Boston Alternative Energy Facility

Appendix E4 to Natural England's Deadline 9 Submission

**Natural England's Comments on Public Rights of Way – Outline Design Guide and
Stopping Up Plan [REP8-007]**

24th March 2022

**PUBLIC FOOTPATH CLOSURES
FIGURE 5.3**

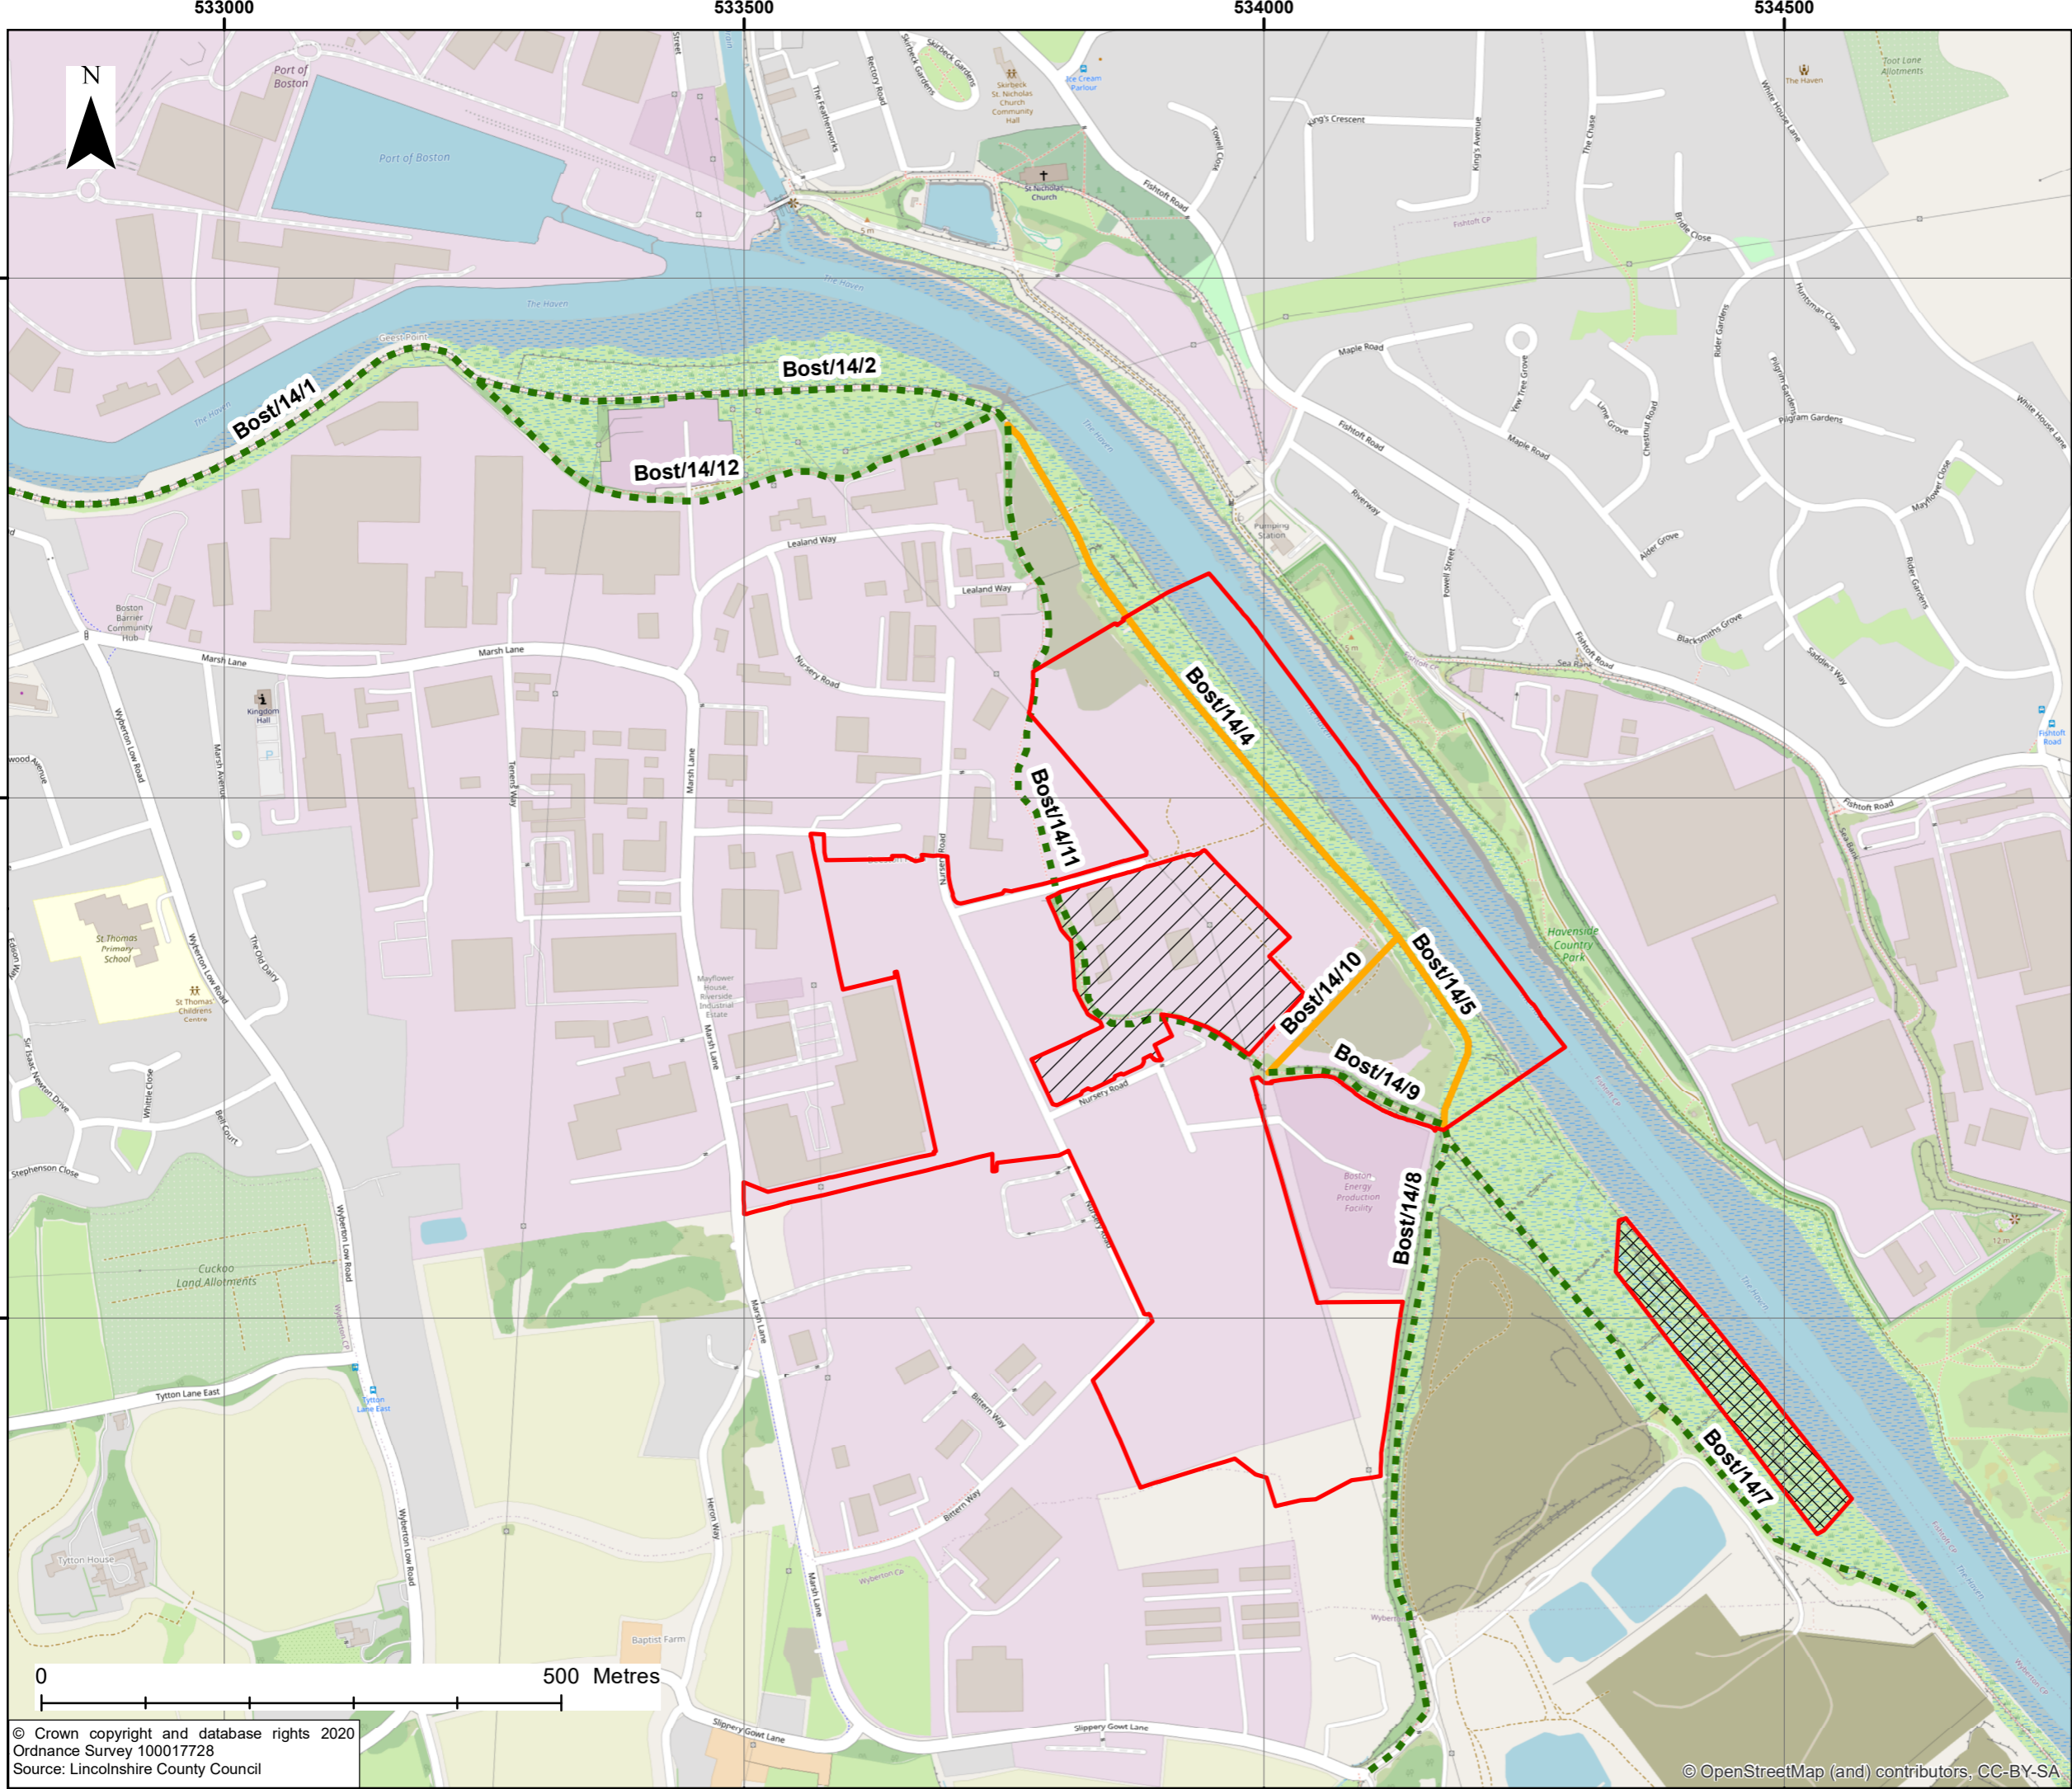
Natural England advises that the route replacement proposed for the England Coast Path would reduce coastal access for future users of the path. We therefore maintain our suggested alternative route which directly follows the coast.

Whilst we acknowledge that stretches of the footpath BOST/14/4 are visually poor and unattractive; the northern stretch of the route is on top of the seawall and therefore has views of the sea. As a Public Right of Way, it should be maintained by the local authority and when it becomes a National Trail this maintenance expectation and quality of route increases. Therefore, once this stretch of path falls within in the England Coastal Path designation it could be enhanced.
